From: Simon Davis
Sent: 27 June 2018 08:55
To: Planning.Responses
Subject: FW: 97 Barnham Road, Eastergate - EG/107/17/DOC

Number
S17-03-01 E

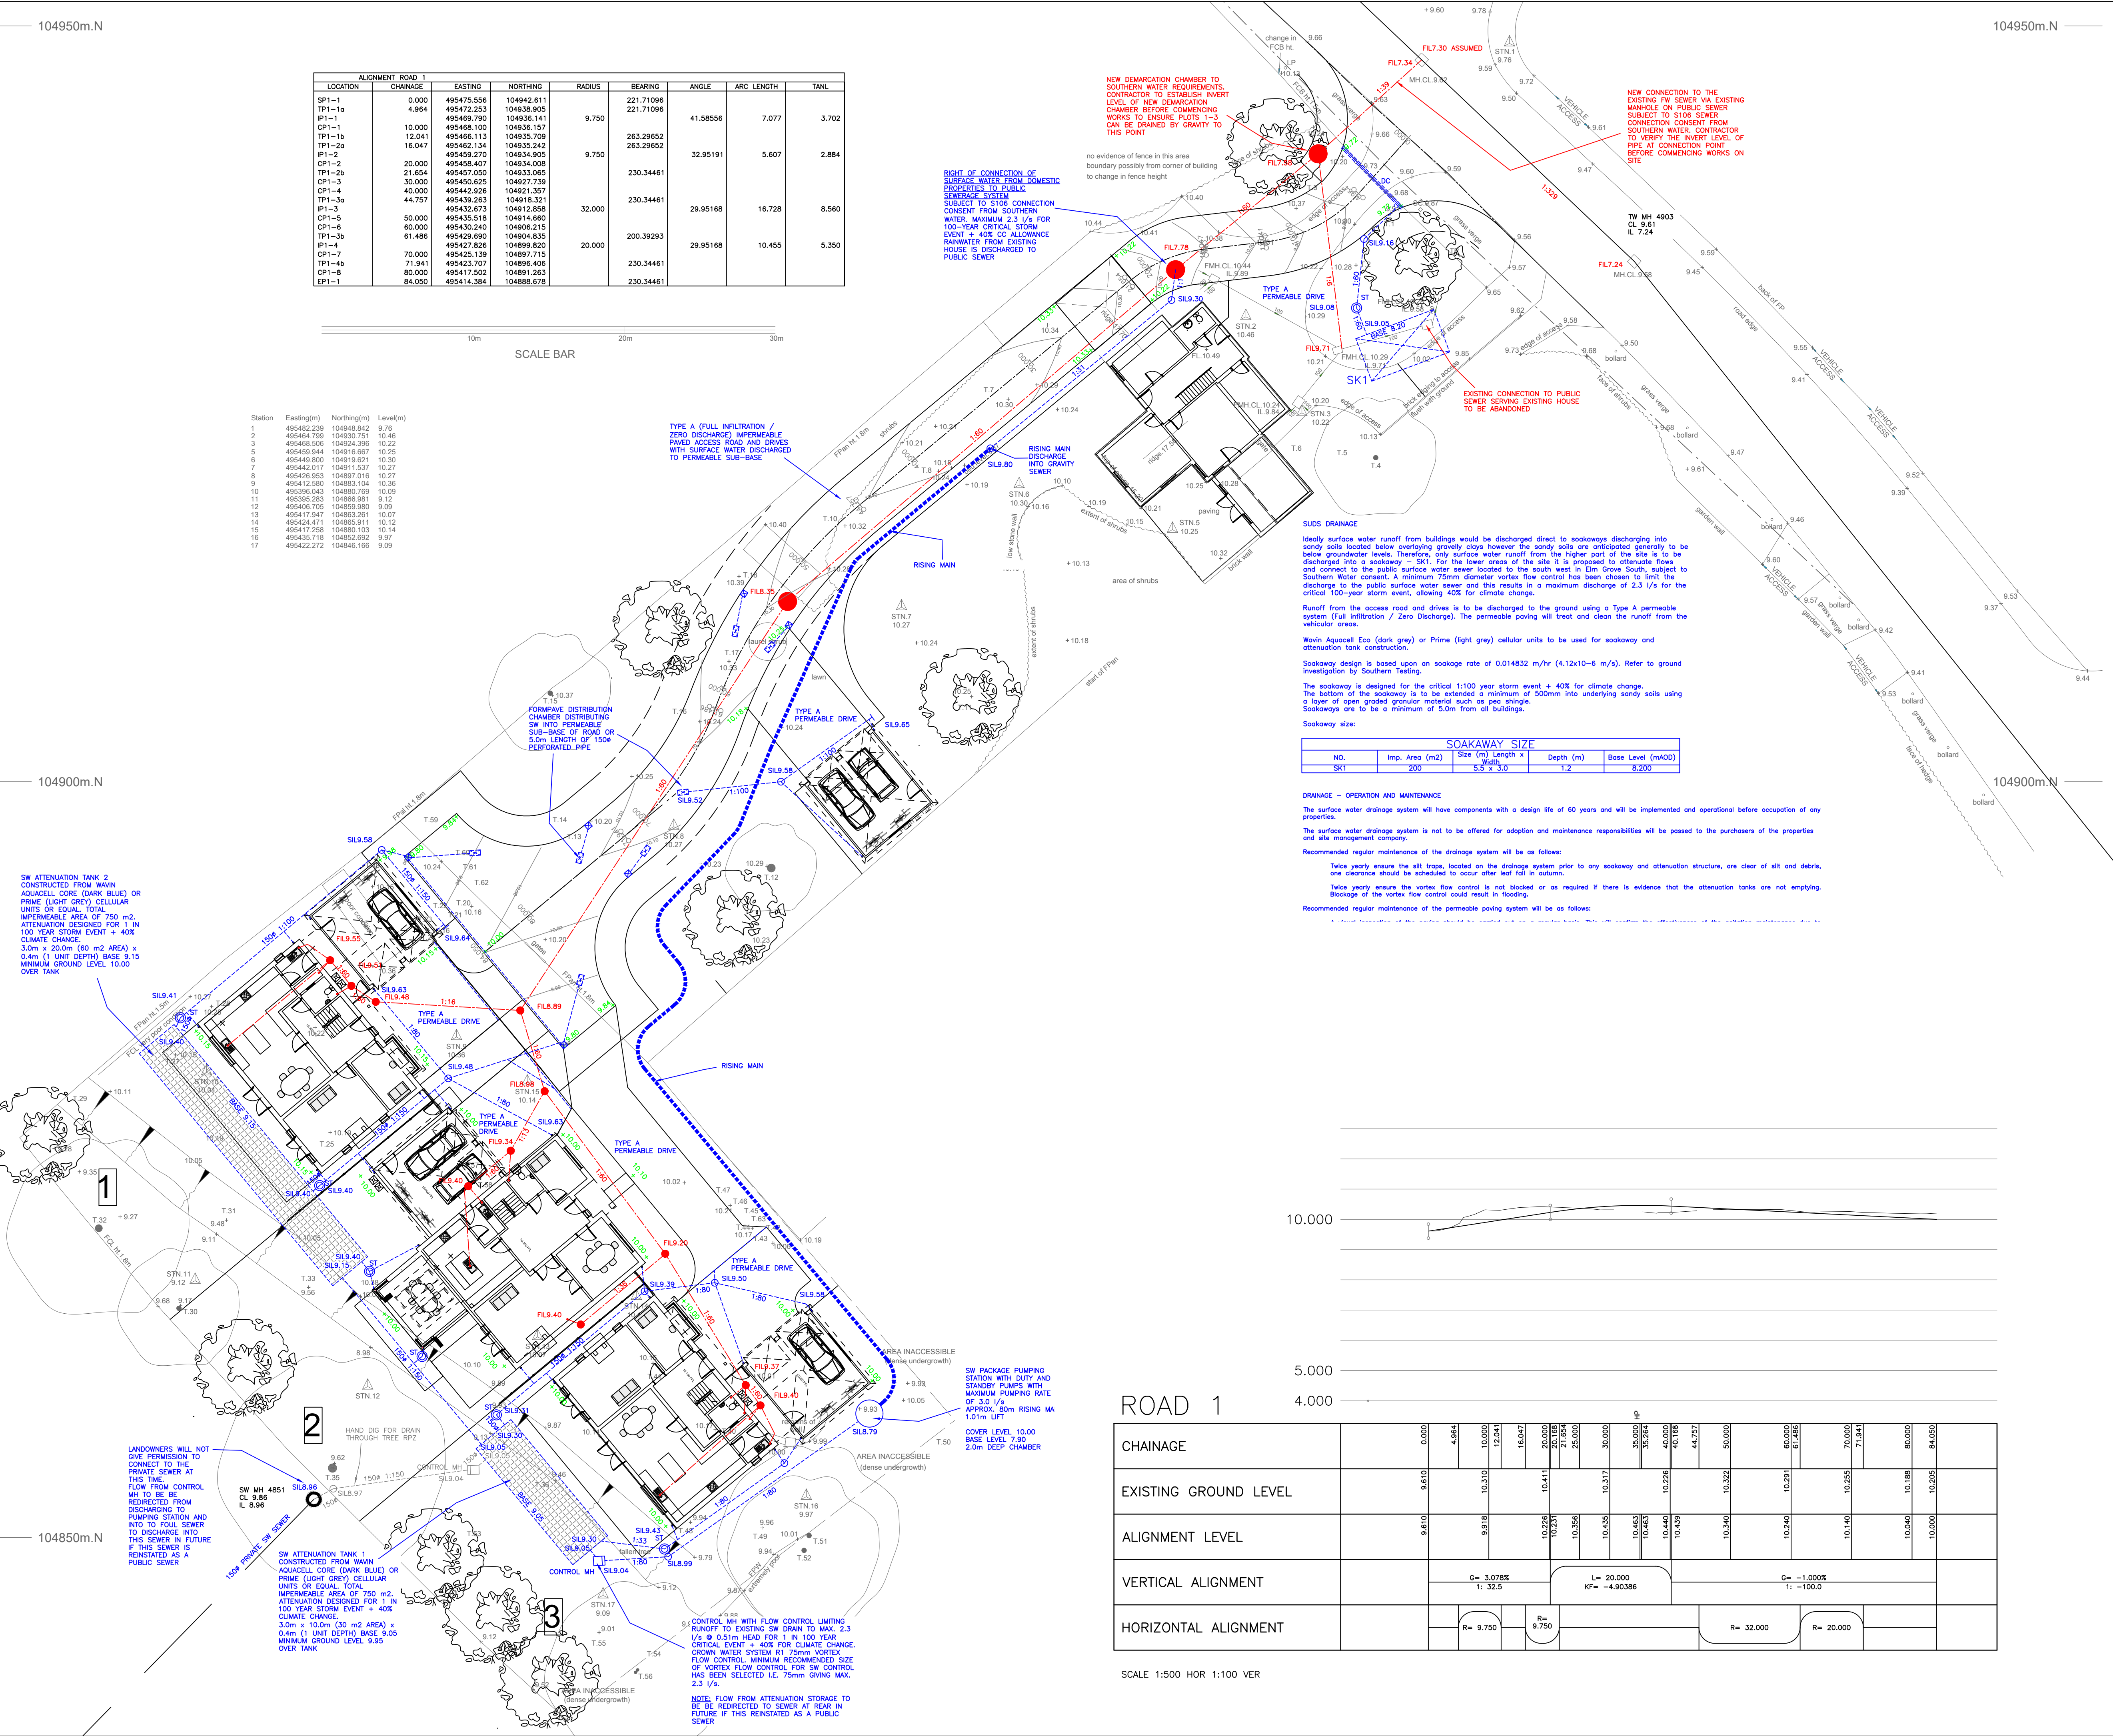
On this occasion, we will let the lack of thrust blocks and cover depths be permitted.

However, we need to see an additional manhole and length of gravity pipe (to be laid at an agreed gradient) at the downstream extent of the rising main. Not including this could result in serious problems with backing up of foul water and blockages occurring as a result.
